Response to Planning Application

Application ref: Y/19/20/RES

Description: Approval of reserved matters following outline consent Y/80/16/OUT for 4.5ha of residential development comprising of 3.4ha of land for the erection of 100 No. dwellings (up to 30 (30%) affordable housing) **together with 1.1ha of land set aside for public open space & strategic landscaping & 2.2ha of public open space & green corridors** with vehicular access from Ford Lane & pedestrian/cycle access only from North End Road. This application may affect the setting of listed buildings, affects the character & appearance of the Church Lane, Yapton Conservation Area & affects a Public Right of Way.

Location: Land to the south of Ford Lane and east of North End Road Yapton BN18 0DS

Sections location plan scale 1:50 @ A2

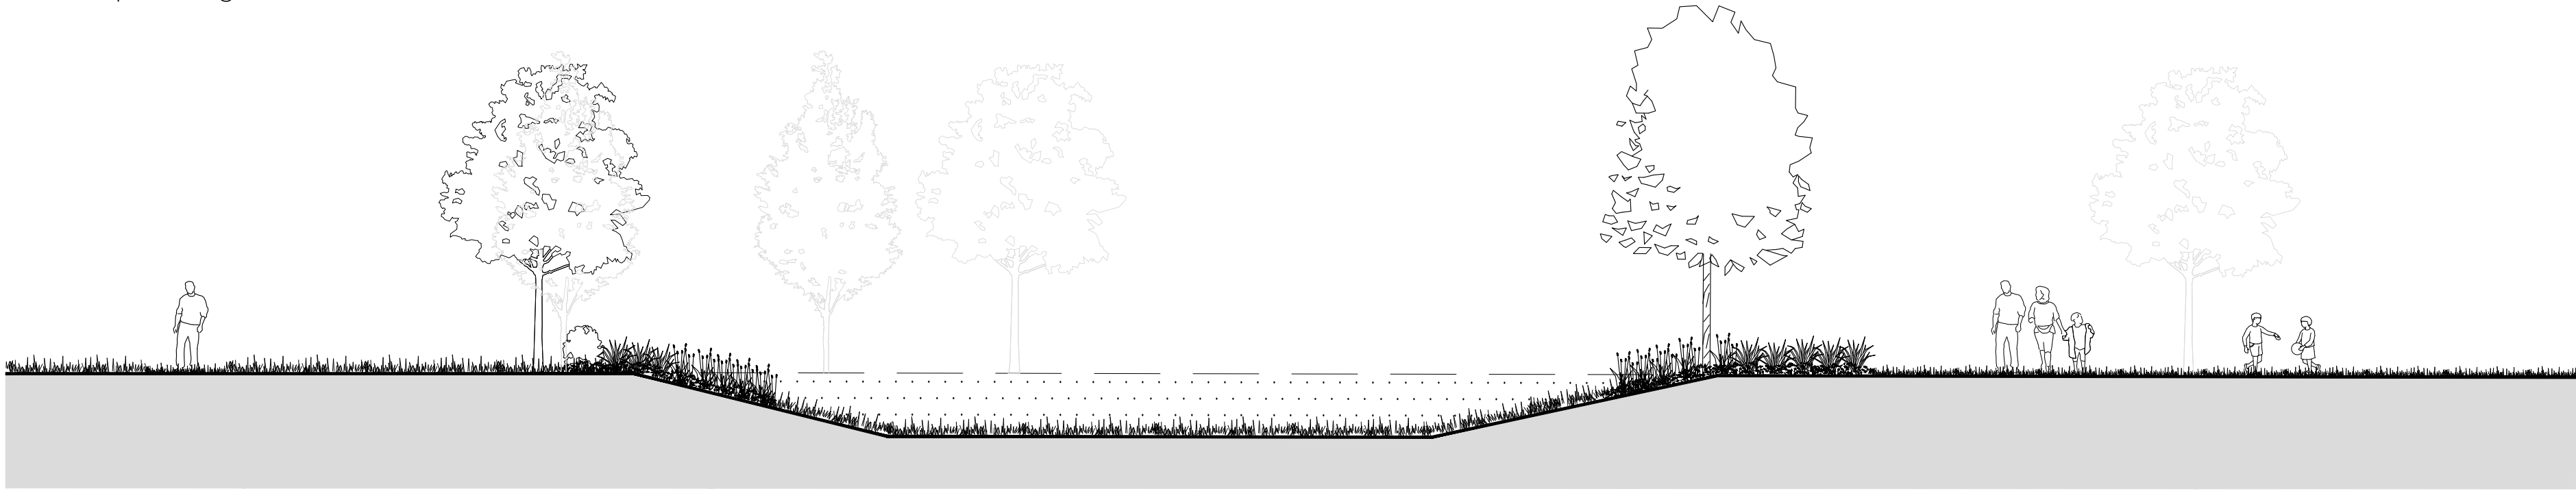
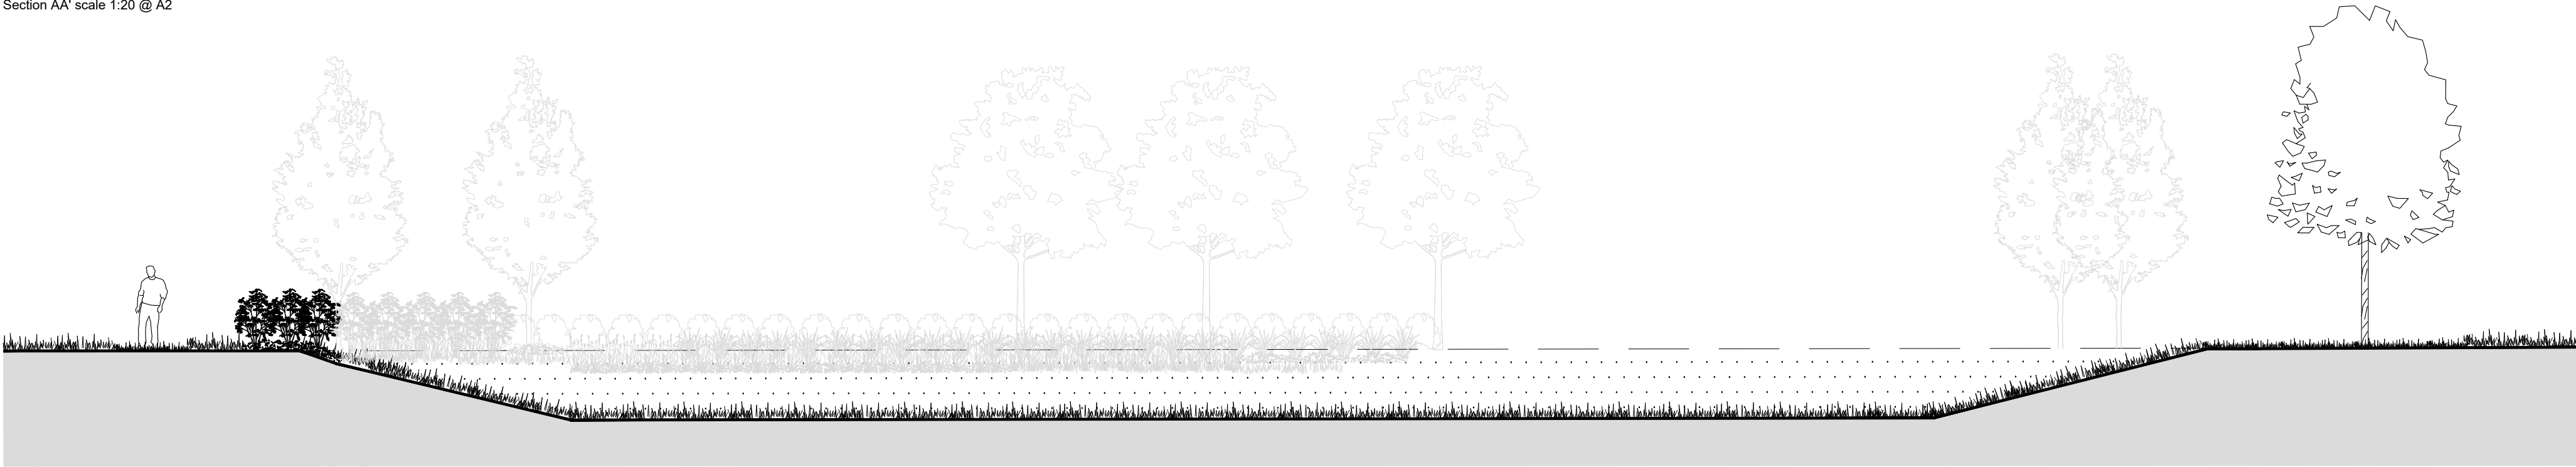
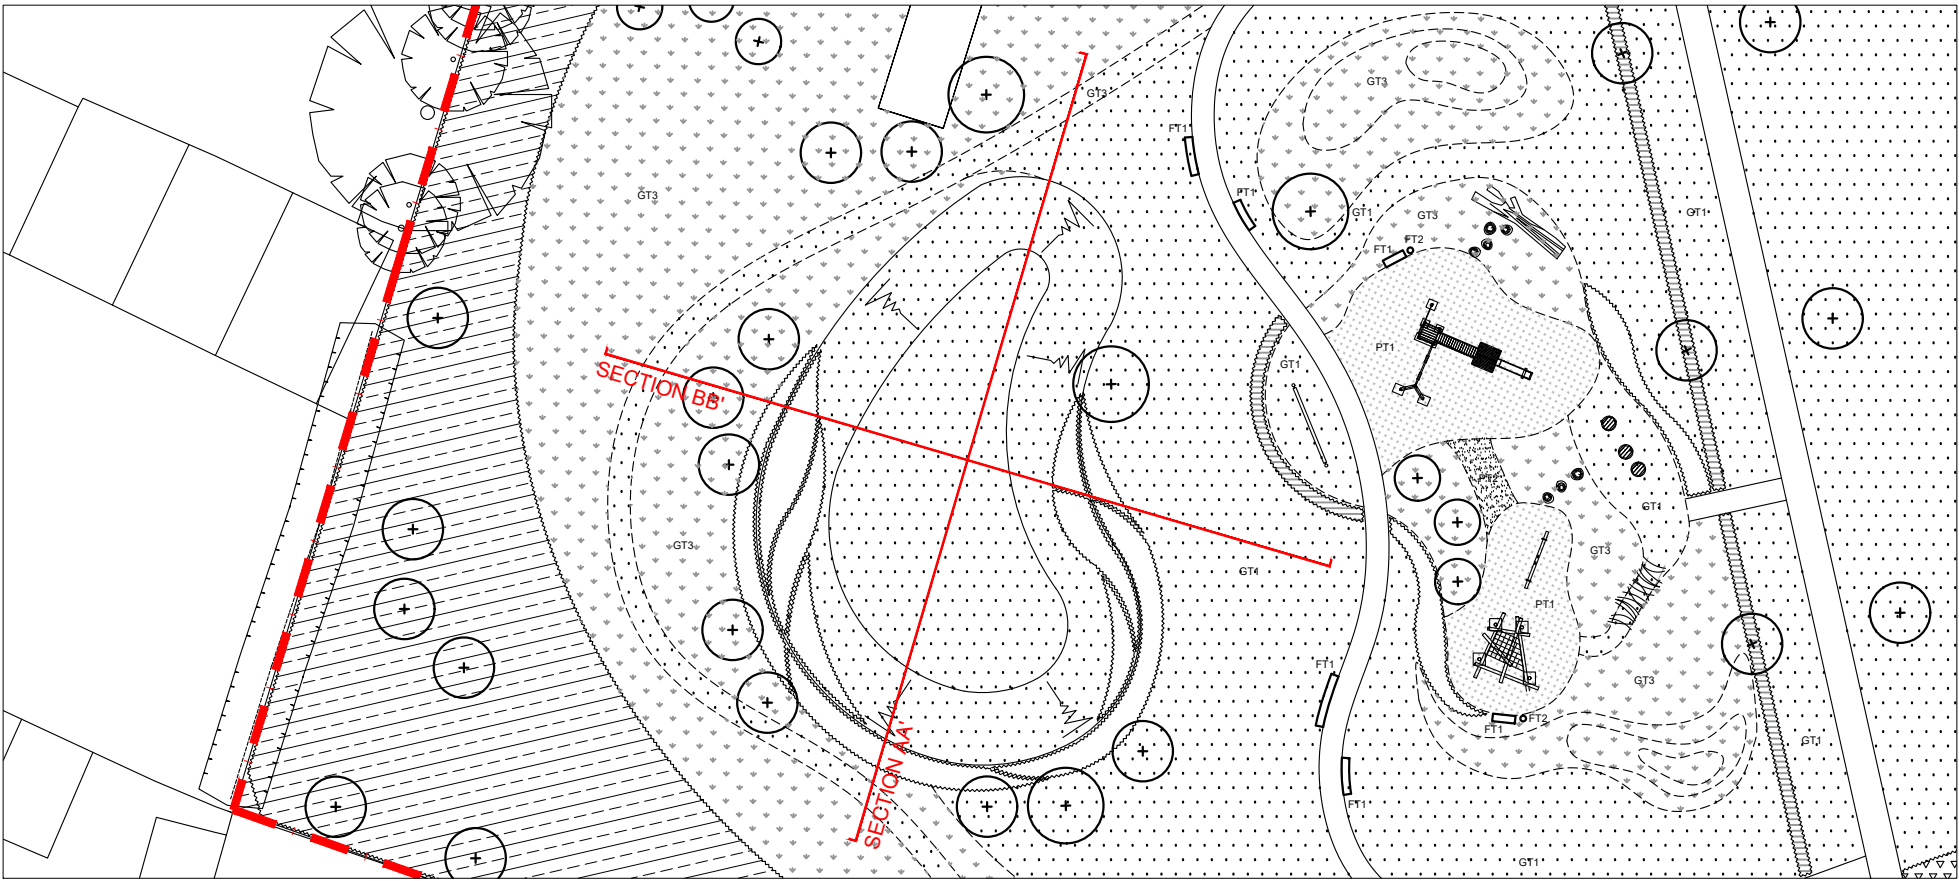
We note the requirement for the large SuDS infiltration basin shown within the POS and the inclusion of marginal planting to integrate this as a positive design feature within the scheme. We would recommend clarification of cross sections and anticipated water holding periods along with any boundary treatment to the SuDS because of the location in relation to dwellings and play. We would advise that ROSPA or similar body are consulted re the proximity of these two features.

Play Area (LAP 2) - Scale 1:100@A1

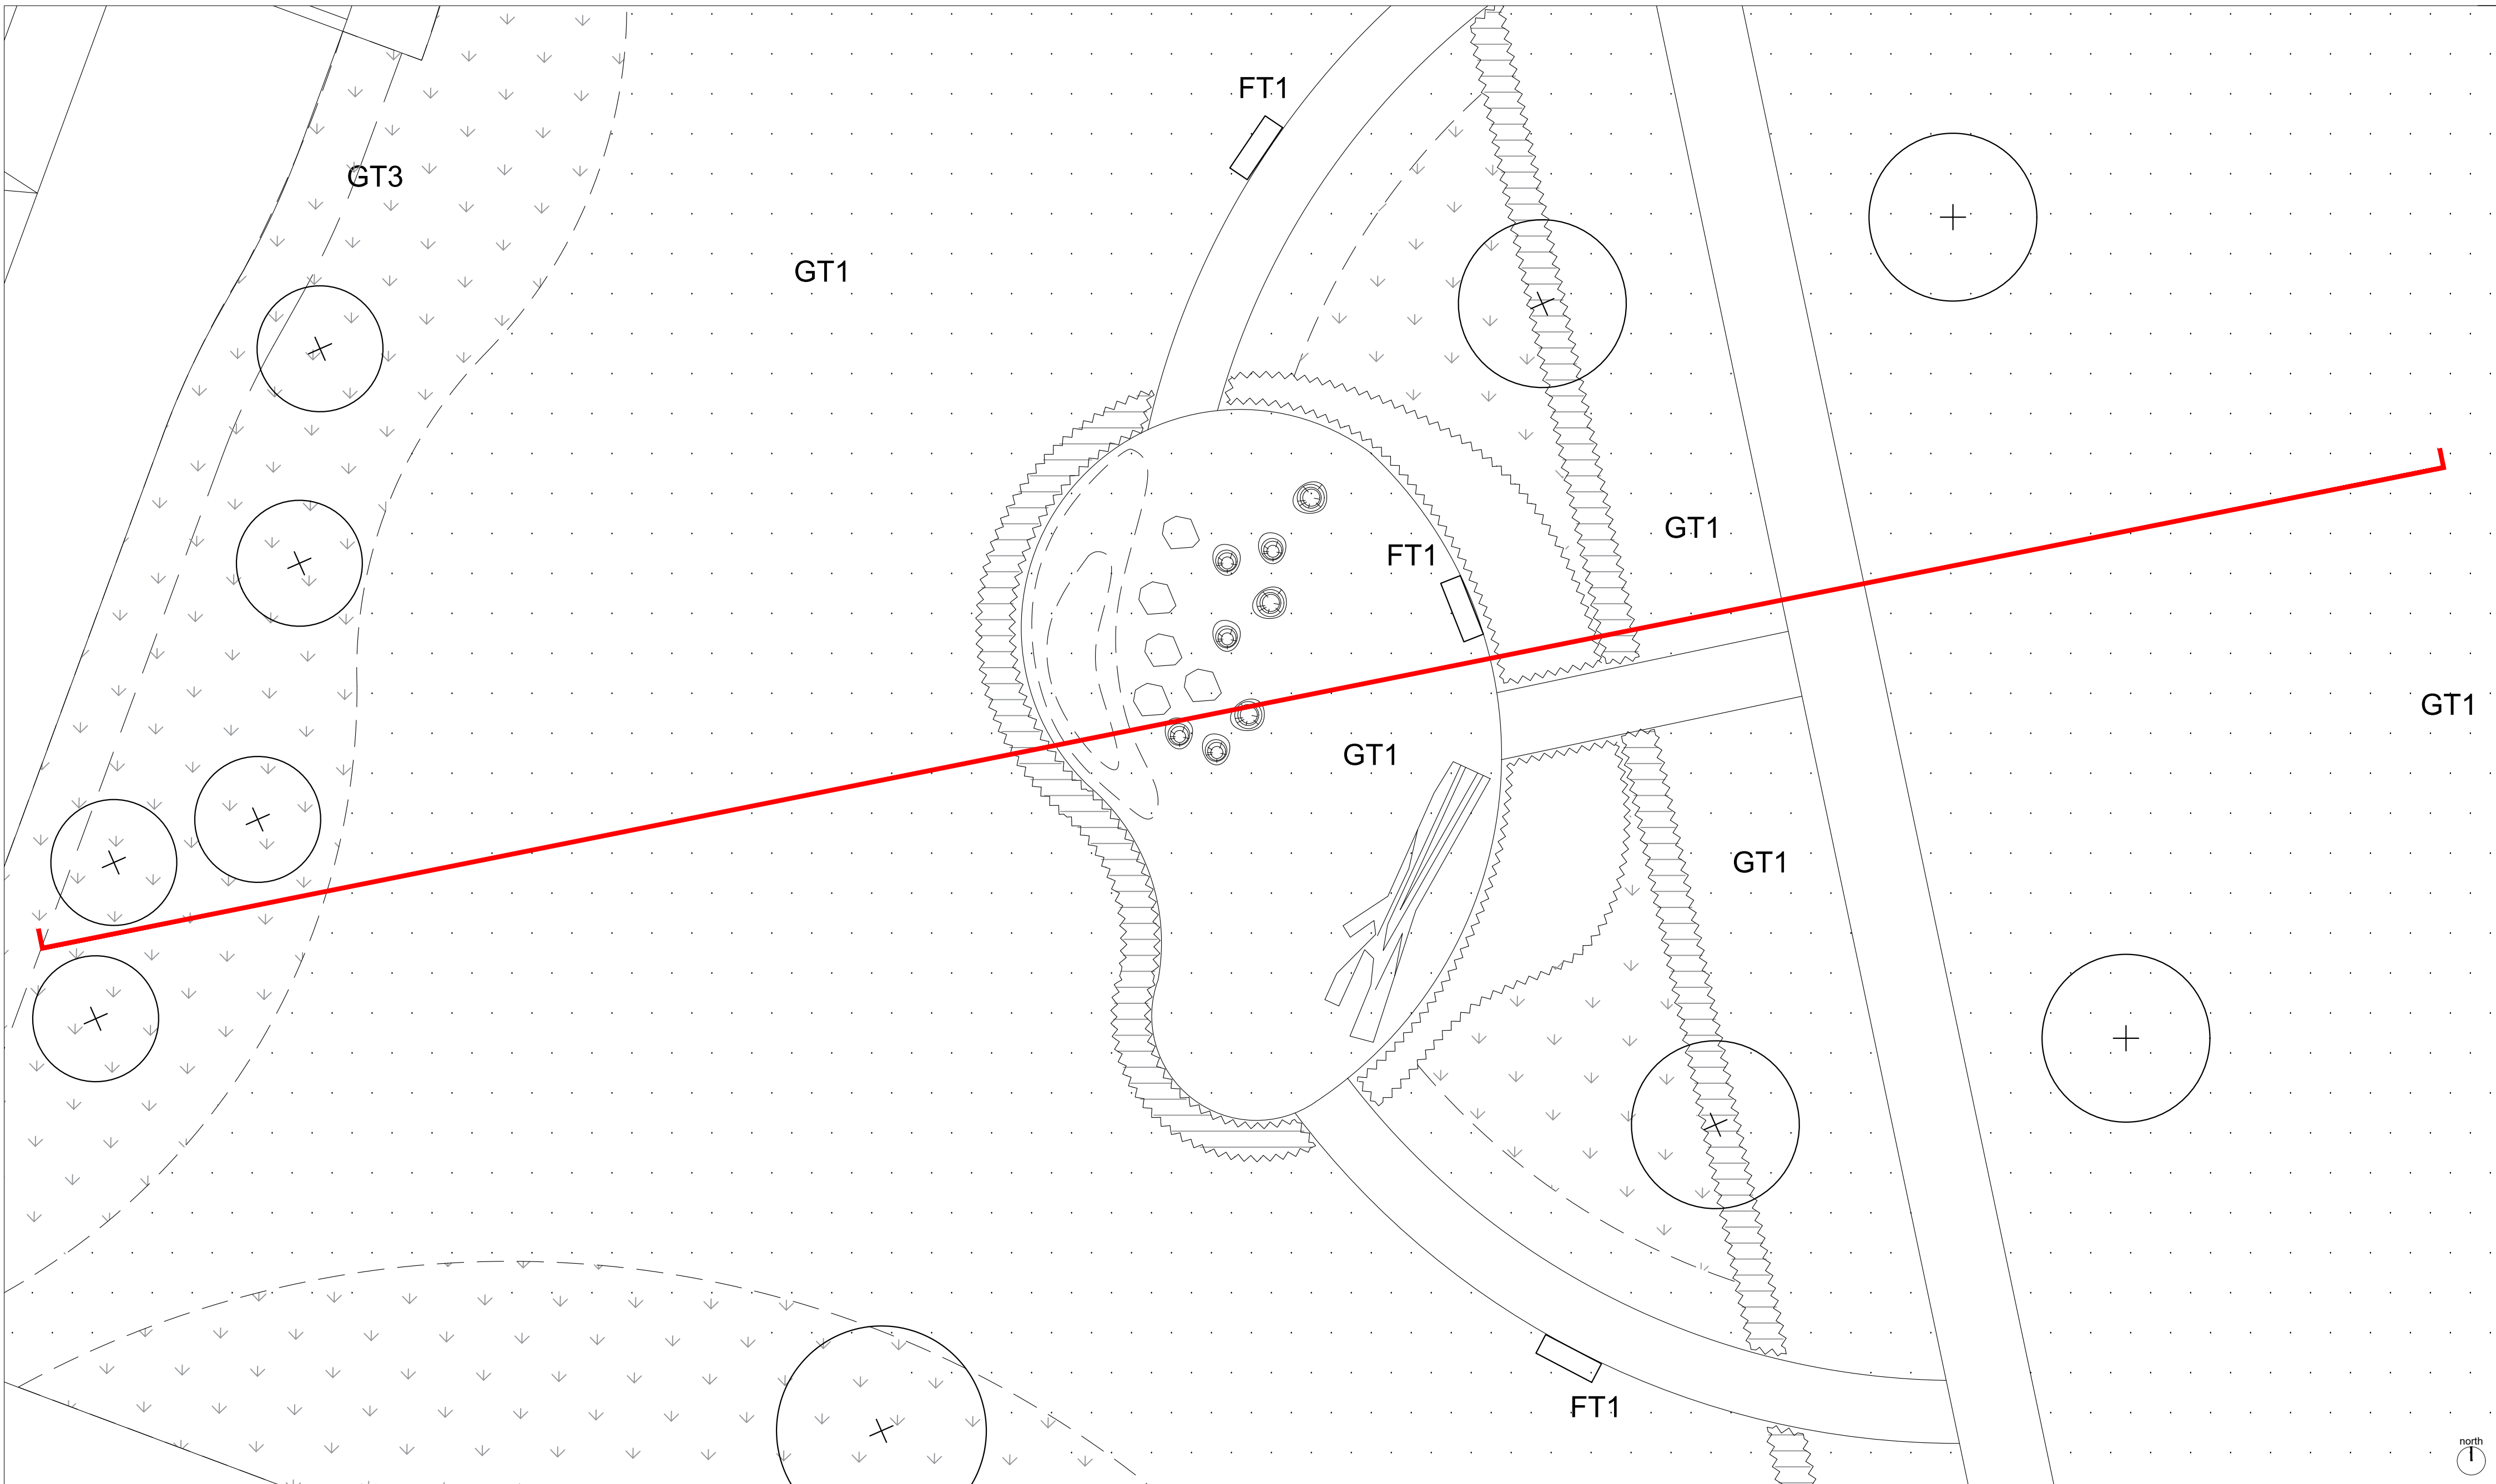
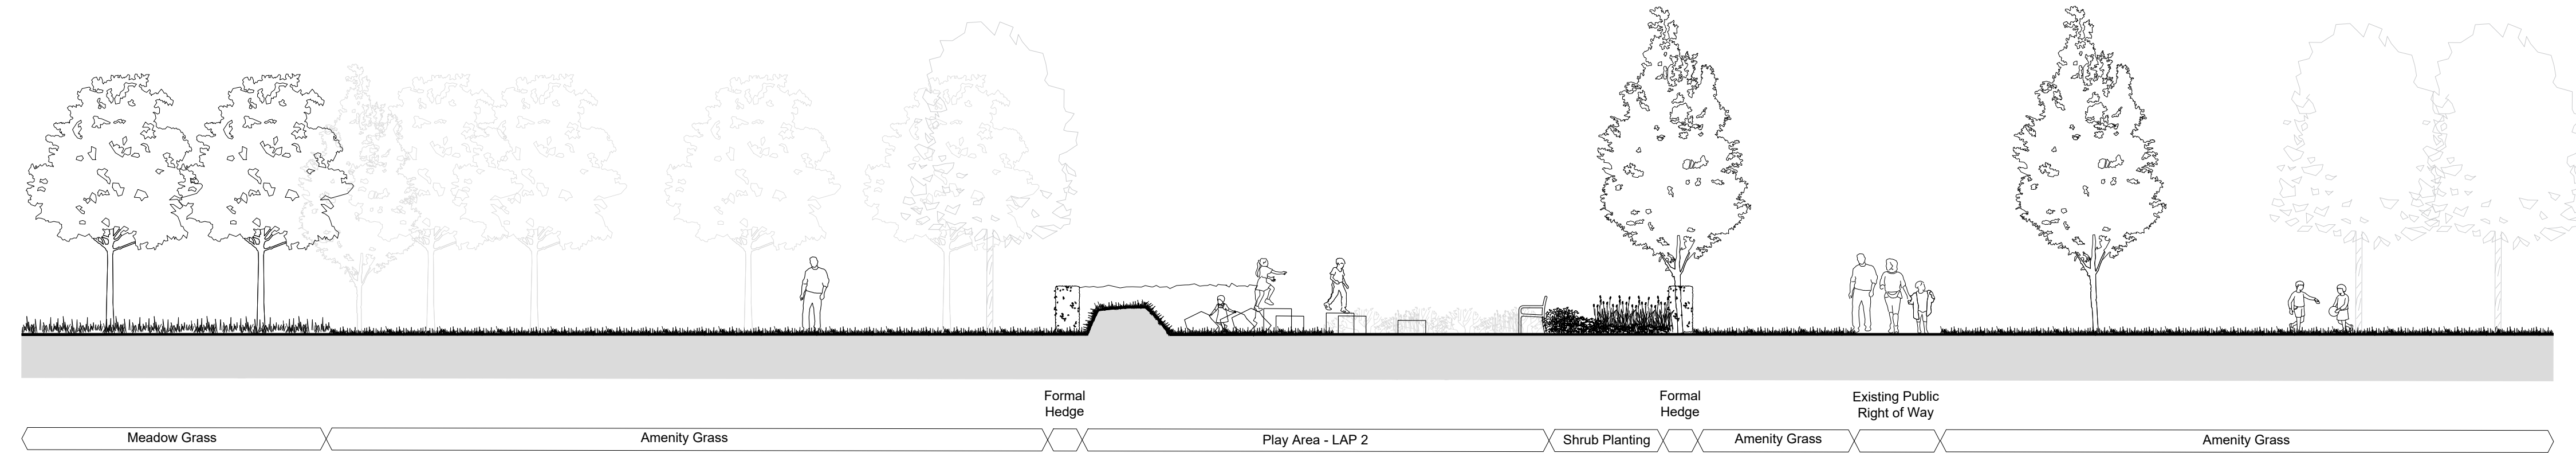
The drawings show multiple LAP and 1no LEAP, however there doesn't appear to be any detailed plans which show the proposals for these and the play provision offered. We would need to see the equipment choice, surfacing, fencing and connectivity to the pathway network for the formal play and the design thought for the more informal natural based play space - LAPs
